From: Bruce Taunton
Sent: 24 February 2010 12:44
To: Planning.Responses
Subject: RE: Planning Consultation on: LU/357/09/DOC at Travis Perkins Site

Registered: 27-JAN-10
Site Travis Perkins Site Pier Road Littlehampton BN17 5BB
Address:

Description of Works: Application for approval of details reserved by condition 4 of planning application LU/175/08

INITIAL
PROPOSED SITE LAYOUT

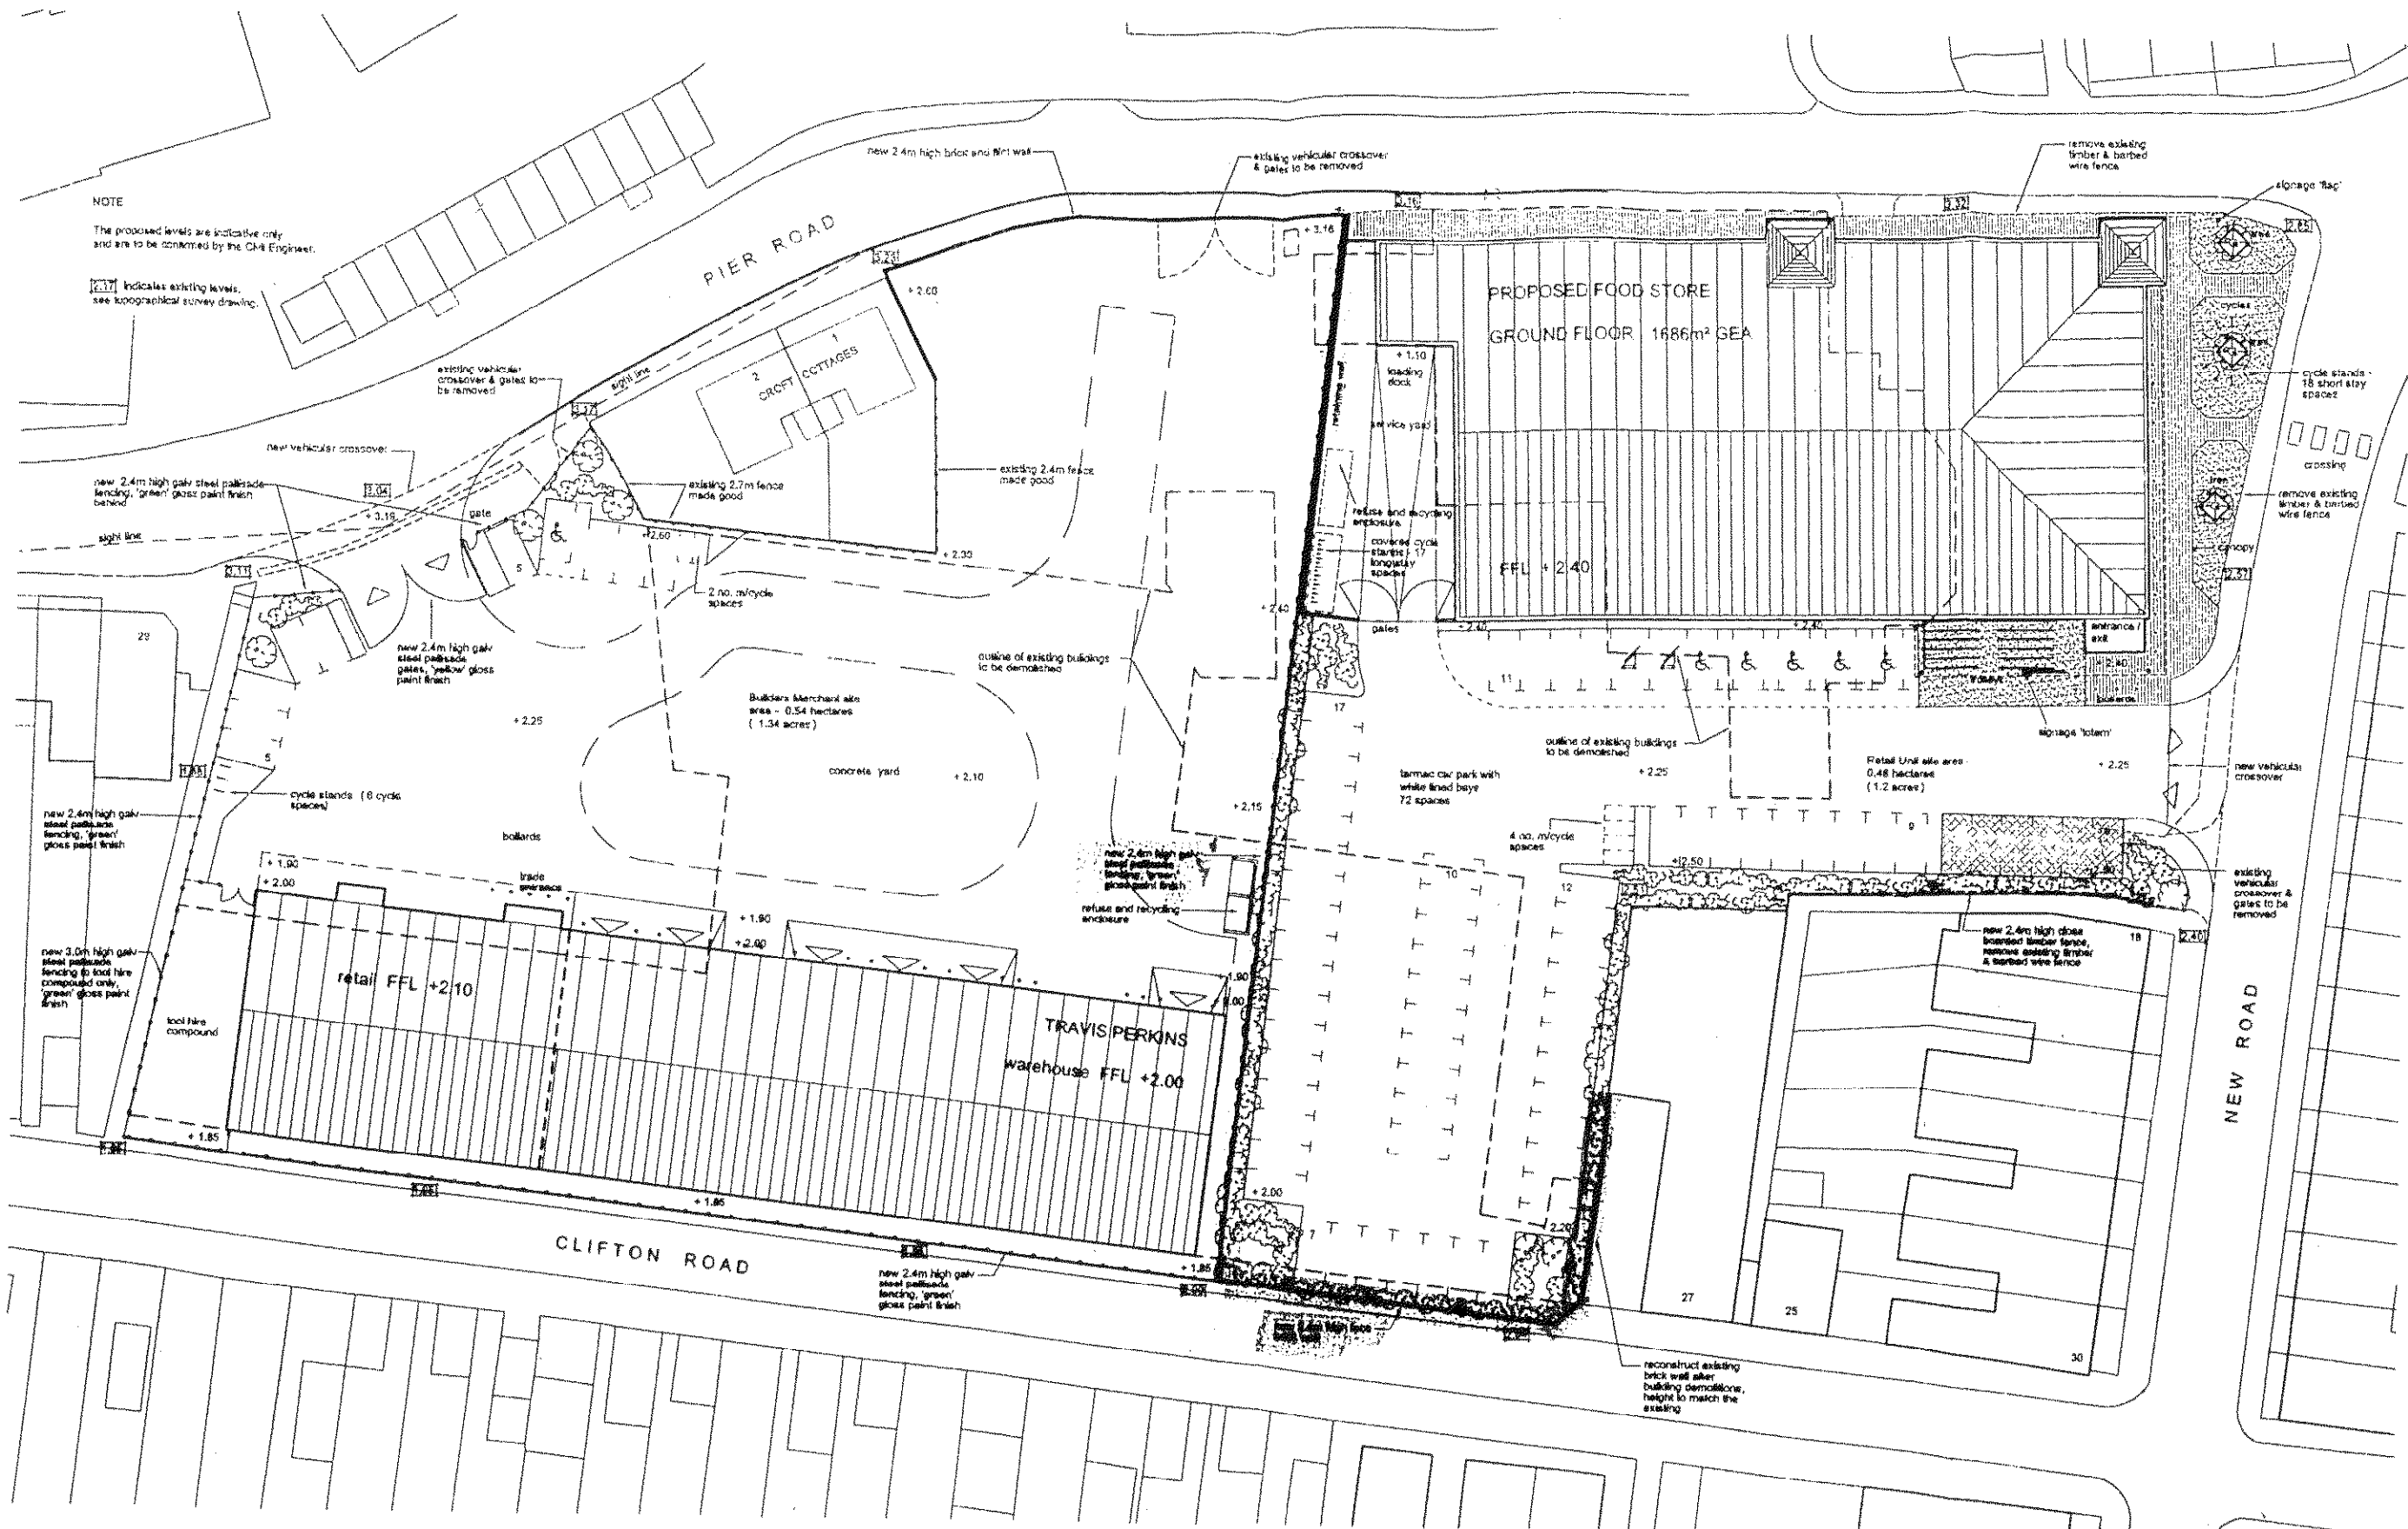
Having reviewed the information we will require structural design and details for the masonry walls including location of expansion joints.
